From: Simon Davis
Sent: 07 October 2020 17:05
To: Natalie McKellar [REDACTED]
Cc: Kerry Simmons <[REDACTED]>
Subject: RE: Springfield, Hook Lane - AL/64/20/PL

From: Natalie McKellar [REDACTED]
Sent: 02 October 2020 13:37
To: Simon Davis <Simon.Davis@arun.gov.uk>
Cc: Mark Warwick <Mark.Warwick@arun.gov.uk>; Kerry Simmons [REDACTED]
Subject: Springfield, Hook Lane - AL/64/20/PL

In terms of the comments regarding drainage, as demonstrated by drawing no. 602/01 Rev C prepared by Kazy's Narbutas Consulting, the surface water storage tank has been specifically sited outside of any tree protection areas to the southern site boundary and as such adequately safeguards the retained trees.

Drainage Strategy				Draining The
Engineering Details				
Drawn	Checked	Scales	Paper Size	Date
JN		1:250	A1	08.19
Job No.				Revision
KNC/1932	602-01			C

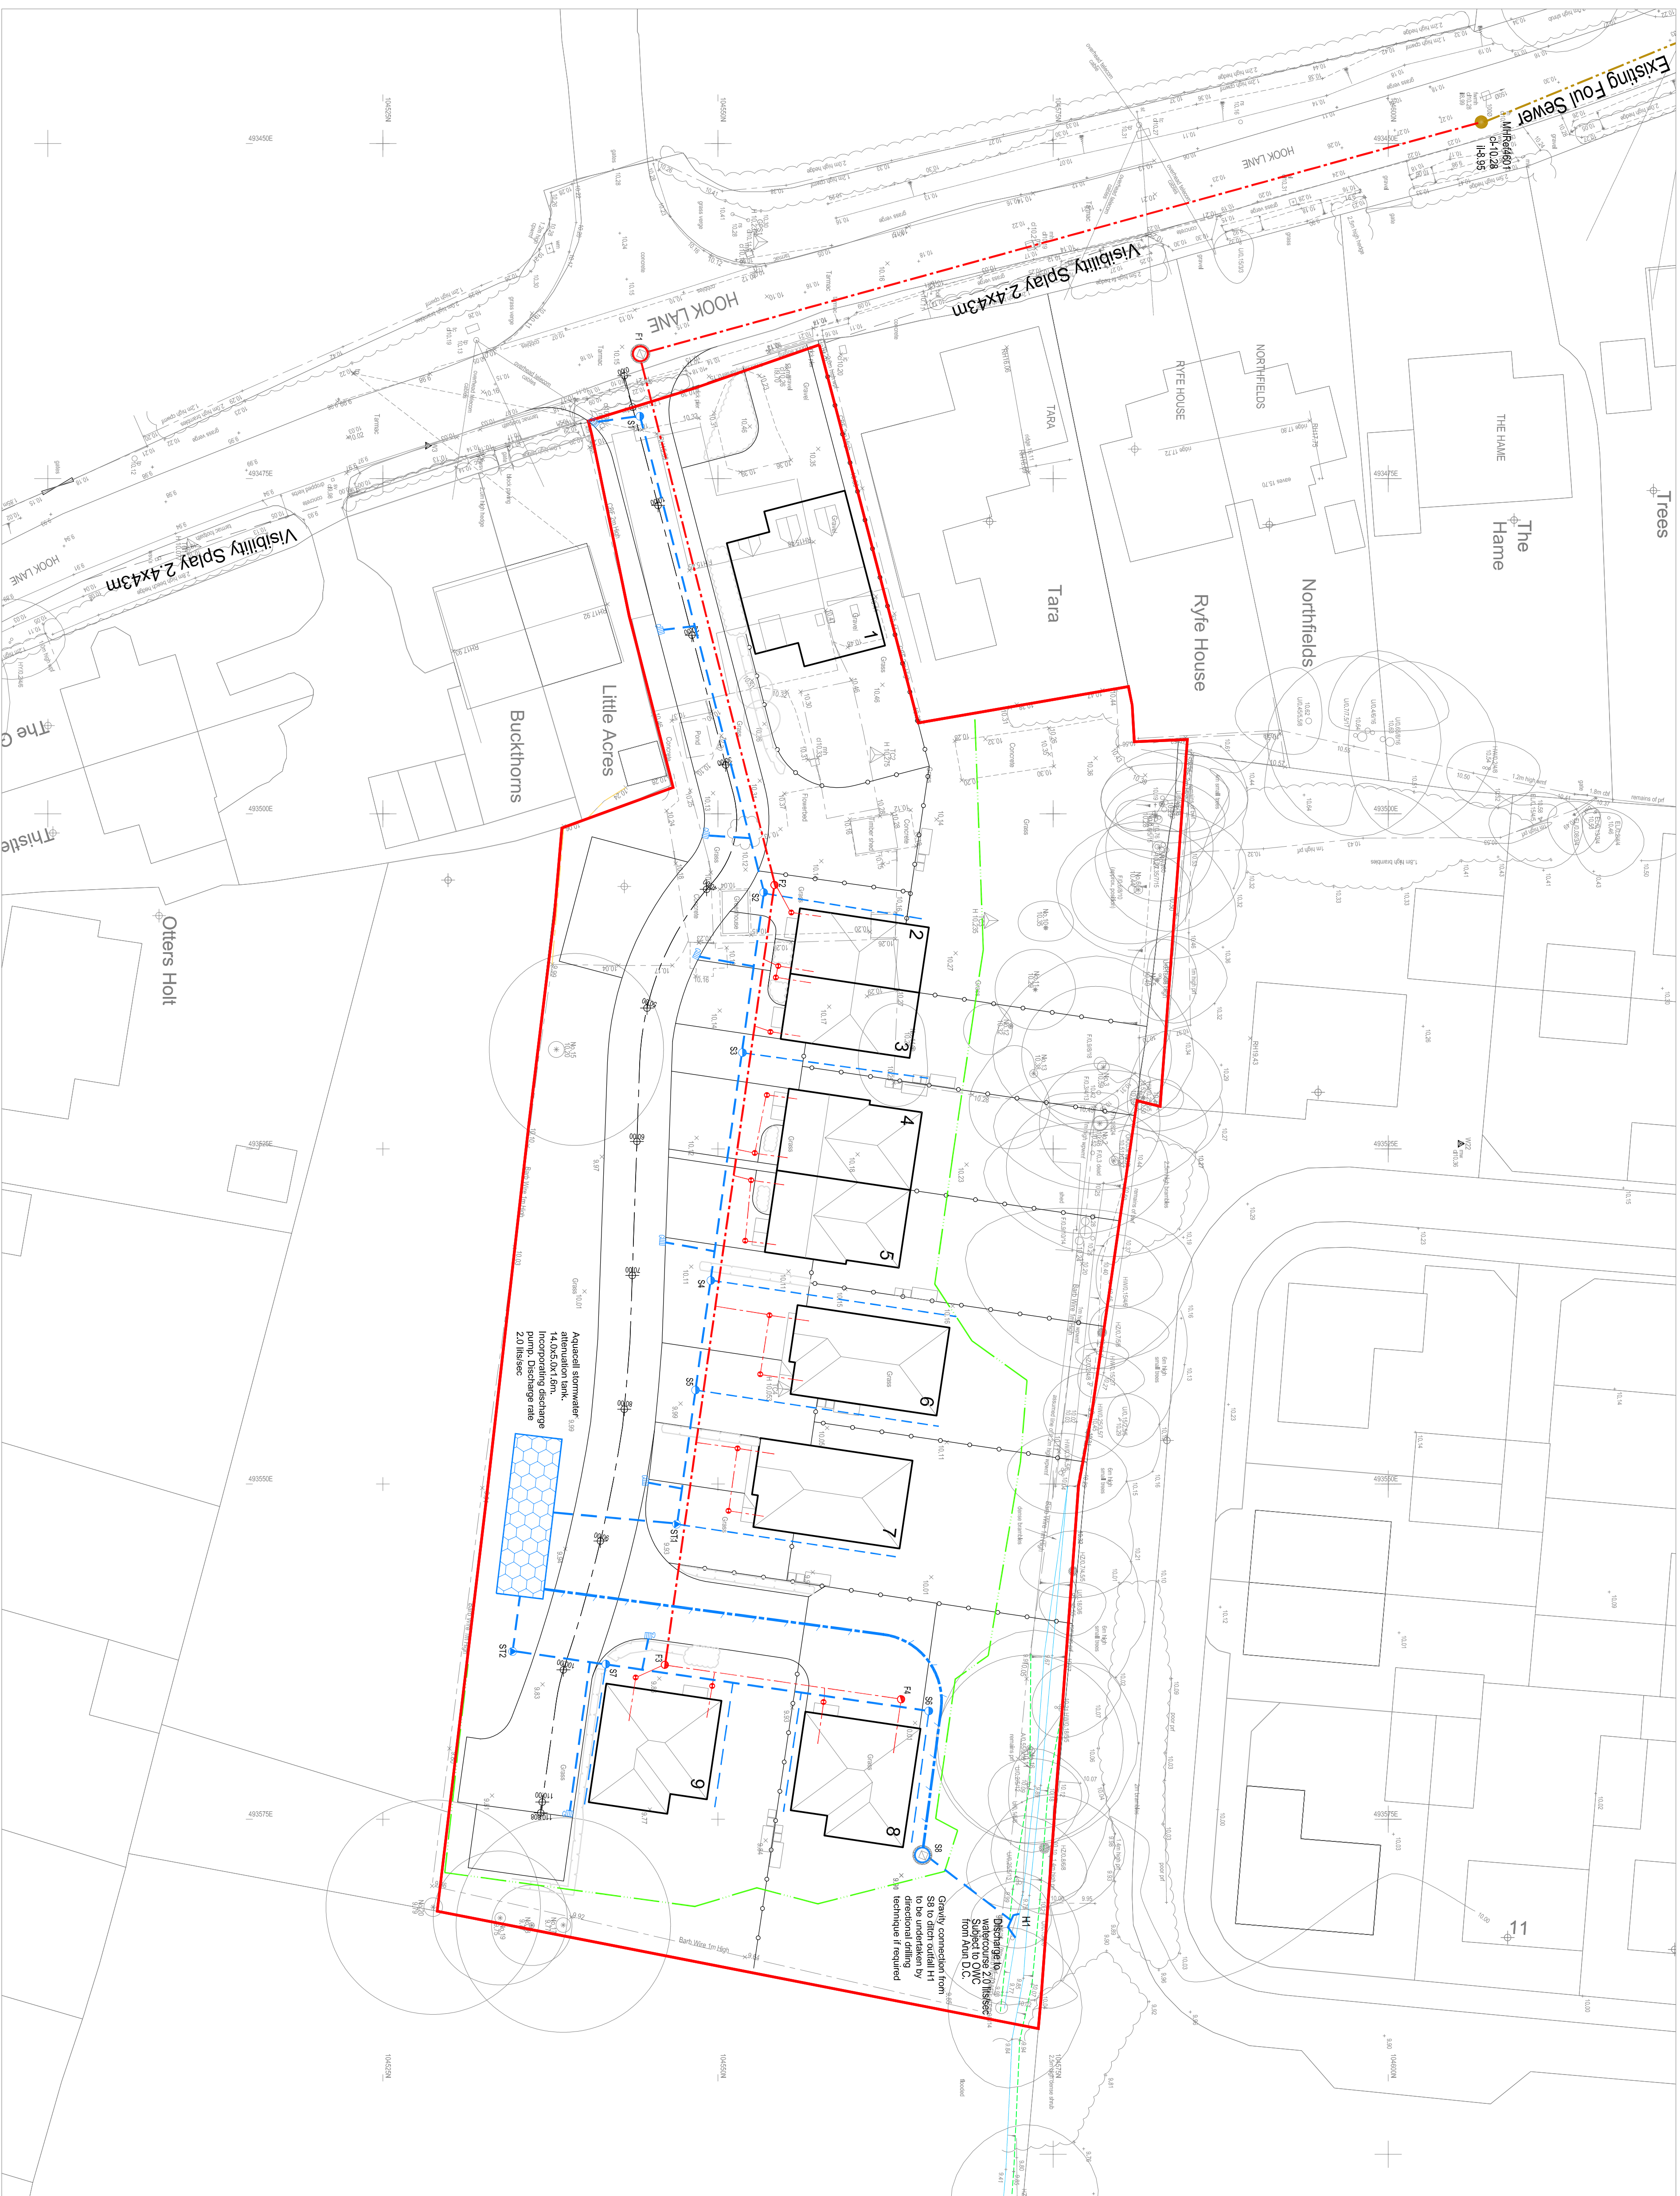
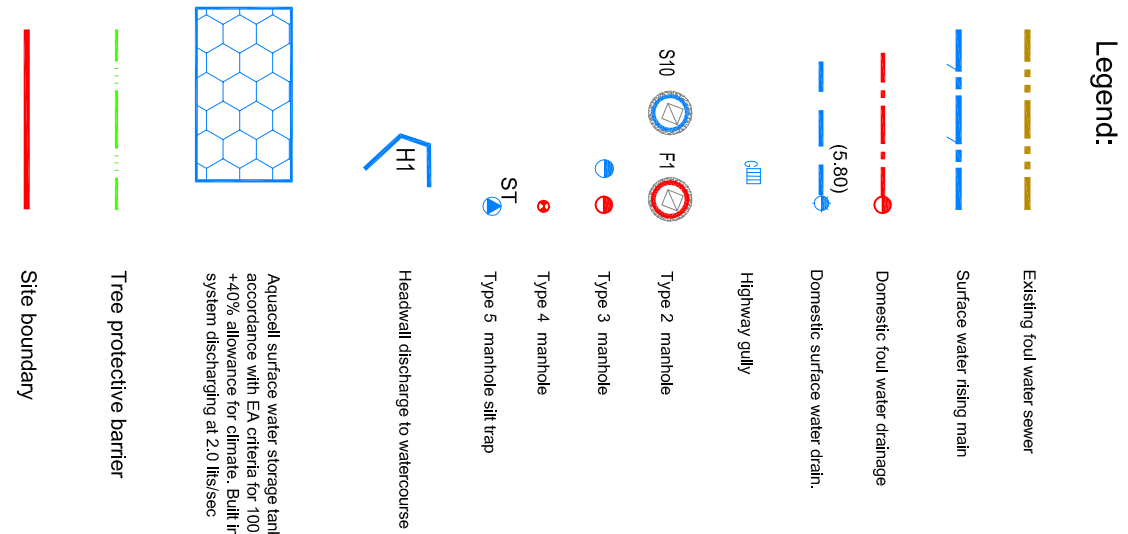
Mark has provided his comments. As you can see, two of the points are resolved but his concern about drainage remains. I put this back to you in case there is anything you could do/provide that would attempt to resolve this last point to Mark's satisfaction. This latest scheme is clearly the least impacting on trees of the three application so far and we may be able to support the application even with this last point unresolved. But it would be helpful if you can at least consider and either make changes or say why you cannot. Can you respond by next Wednesday if possible. If later, then we may need to agree a small Extension of Time.
